| <b>Item No.</b>     | <b>Report of the Head of Planning, Transportation and Regeneration</b>                                                                                                                                                                                                                                                                                                                                                                                                                                                                                                                                                                                                                                                       |
| <b>Address</b>      | SW ADJACENT JUNCTION PUMP LANE/ SILVERDALE RD HAYES

Title: 210 PROPOSED H3G SITE PLAN

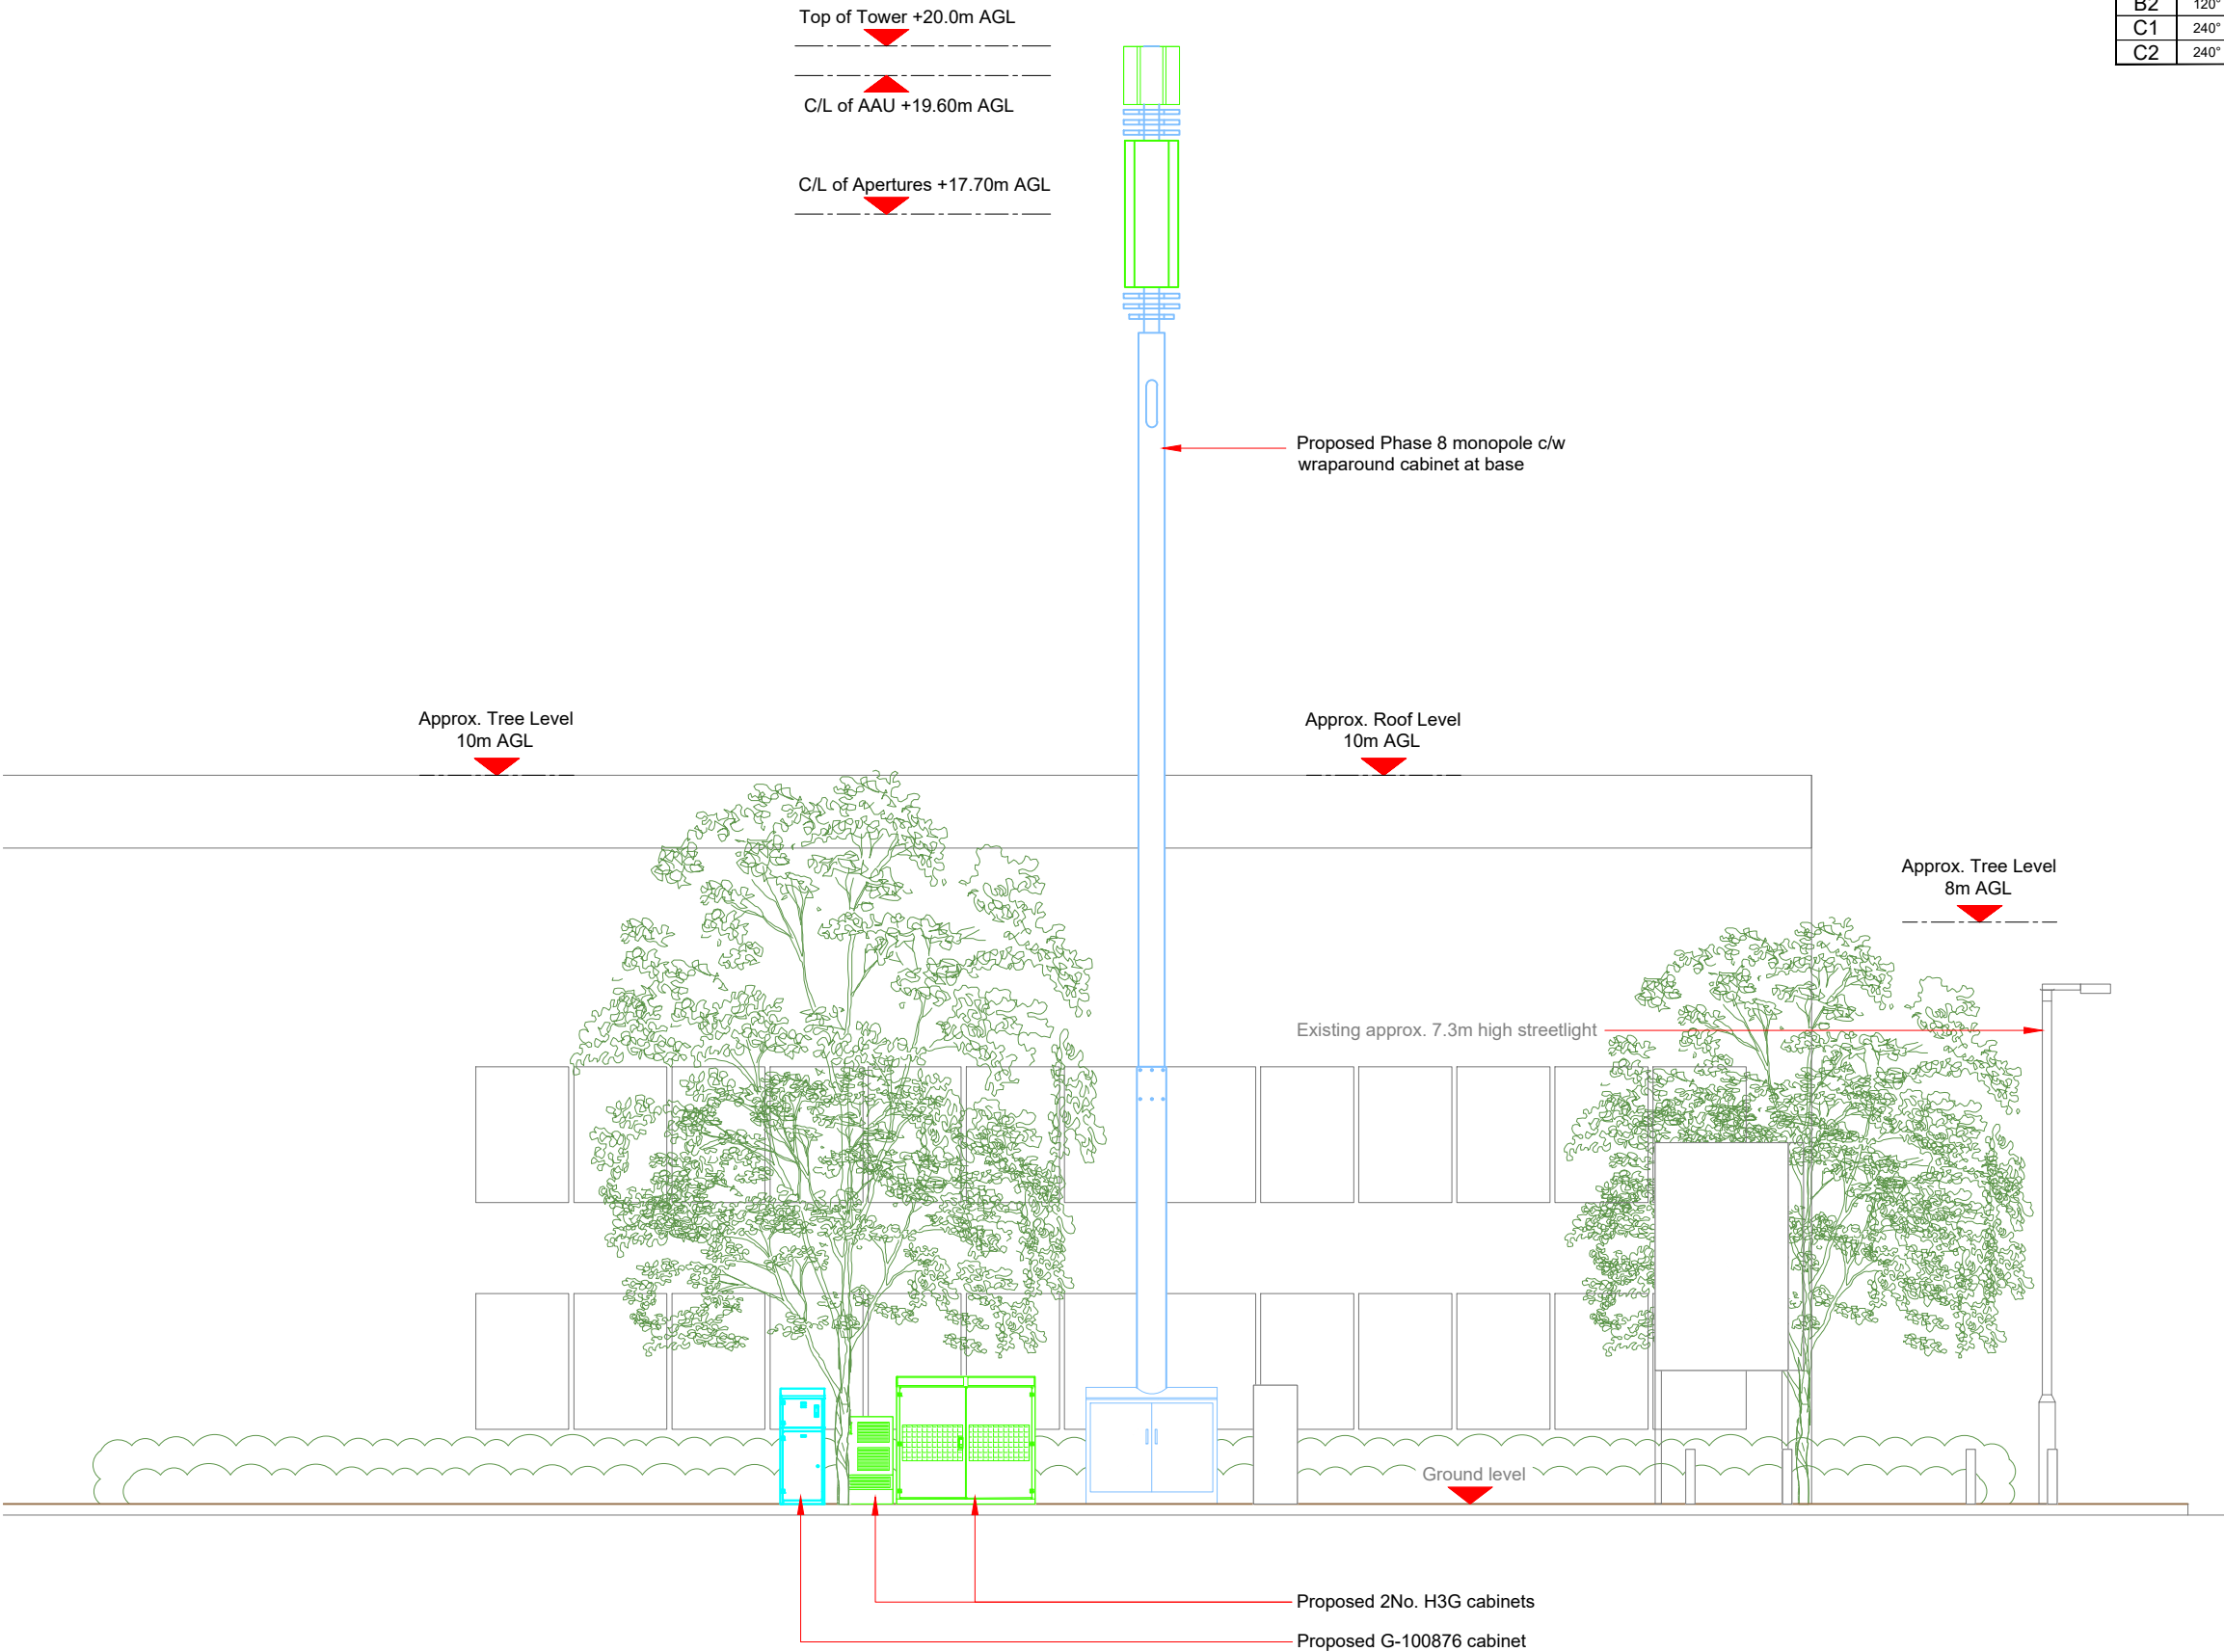
given its site context, there would be limited impact on the character and appearance of the area. However, the location of the cabinets is considered inappropriate and will introduce urban clutter to the footway and otherwise attractive landscape feature.

The application site is located on the paved pedestrian footpath and there is a tree located 3.47m to the east of the monopole with a base cabinet. According to the Arboricultural Impact Assessment, the monopole with the base cabinet is located within the root protection area (RPA) of the tree, referred as T3. The report states that the tree is a common lime with a height of 10m in good condition (category B1 under BS 5837) with estimated remaining contribution as long.

In order to accommodate for the telecommunication equipment, the proposed development would involve the tree to be prune by not more than 1.4 m on the western side and that pruning may be required to maintain distance away from the mast in the future as the tree increases in size. However, the applicant has fail to mention any long-term implementation of maintenance.

The report also states that the "installation of the foundations for the equipment would include some works at the edge of the Root Protection Area of T3, these are expected to be tolerable to the tree because of its age, the distance from the tree, and the availability of better rooting space in the soft verge than beneath the pavement". Based on the plan provided, it shows nearly the entirety of the monopole with the base cabinet is within the Root Protection Area.

The Council's Trees/Landscape Officer have assessed this application and raised objection to the proposal. Due to the close proximity and cabinet's location within the Root Protection Area, concerns are raised on the existing root structure and the plan indicates

that this will unbalance the crown of the tree and spoil its form. The officer has emphasized that until excavation takes place, the full impact of the proposal on the existing root structure cannot be known. Given the above, the existing street tree would be unsustainable with several details which could adversely affect the tree in the medium to long term and will jeopardize the future of a public asset.
